Rosefield Solar Farm

Schedule of Changes to the draft DCO (Clean)

EN010158/APP/8.1.7
Revision 07
Deadline 5
July 2026
Rosefield Energyfarm Limited

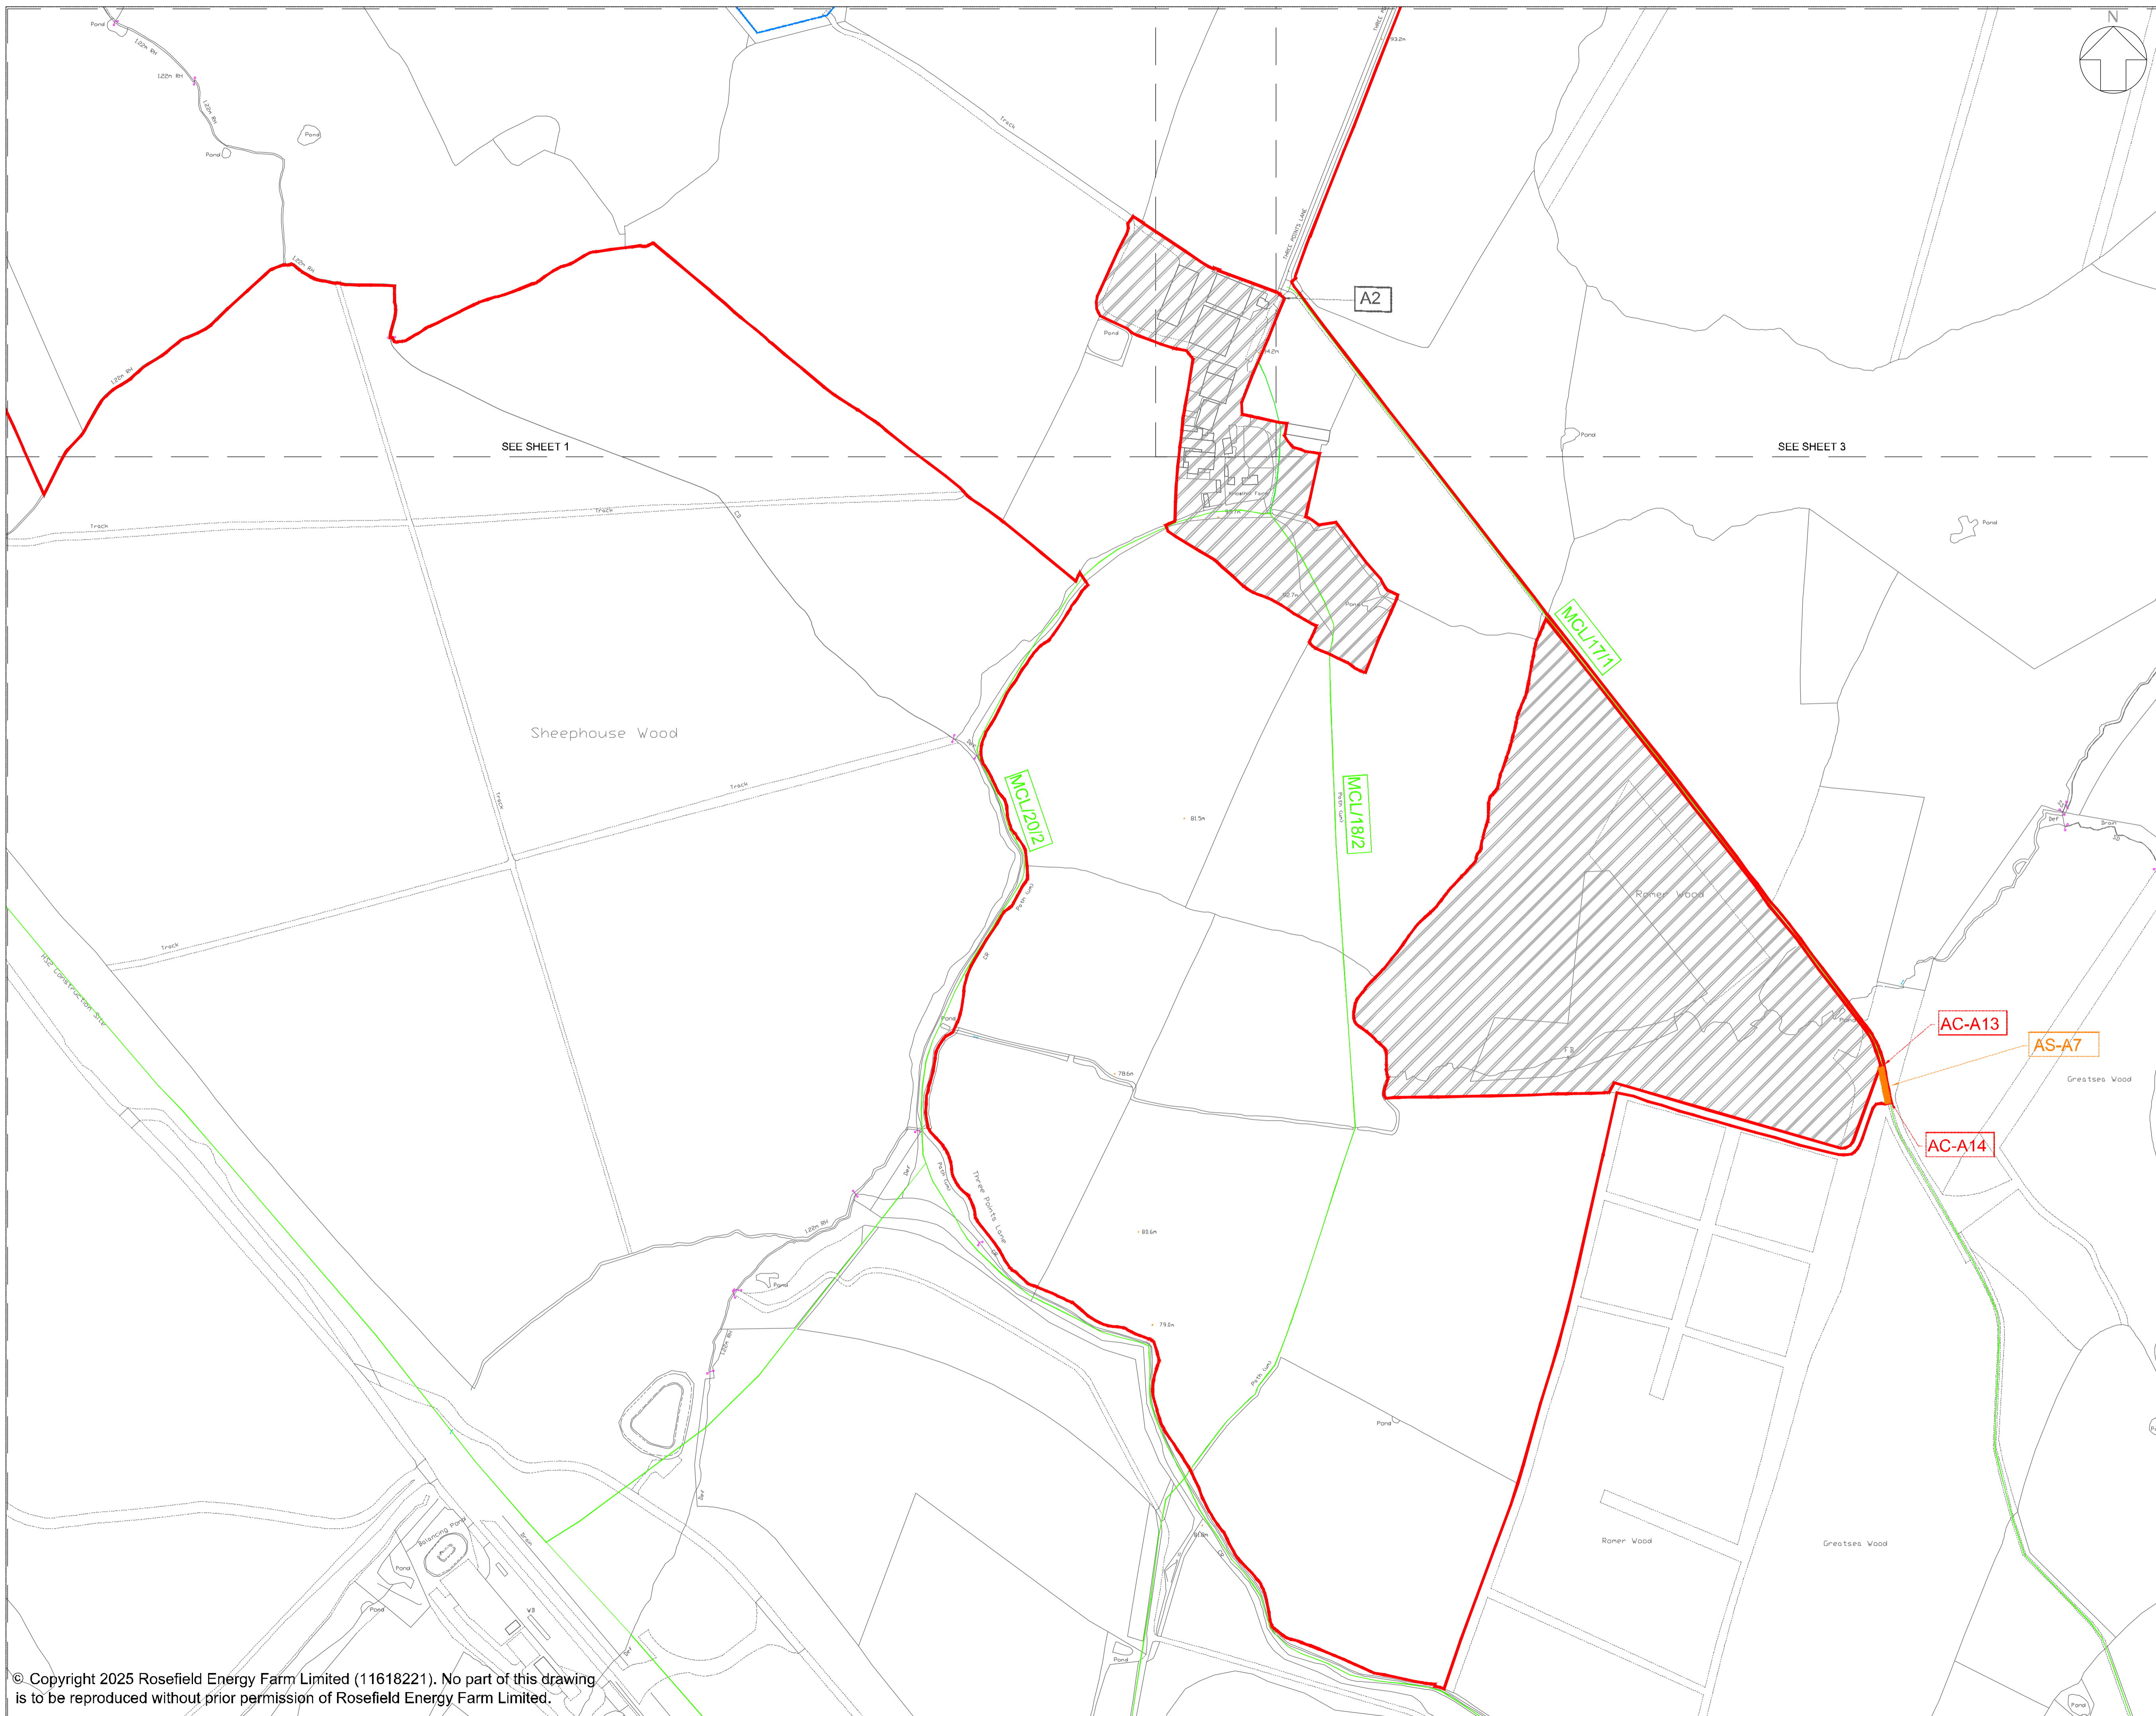
District of Buckinghamshire	SCL/13/1 and SCL/13/2	For a distance of 1,210 metres between points PE-A7 and PE-A3 as shown on sheet 1 of the streets, access and rights of way plans.	New public footpath of minimum width of 2m to be provided between points PE-A7, PE-A5 and PE-A4 and PE-A3 as shown by a cyan line on sheet 1 of the streets, rights of way and access plans.		
	District of Buckinghamshire	SCL/12/2	For a distance of 190 metres between points PE-A7 and point PE-A10 as shown on sheet 1 of the streets, access and rights of way plans.	New public footpath of minimum width of 2m to be provided between points PE-A7, PE-A5 and its intersection with SCL/12/1 as shown by a cyan line on sheet 1 of the streets, rights of way and access plans.
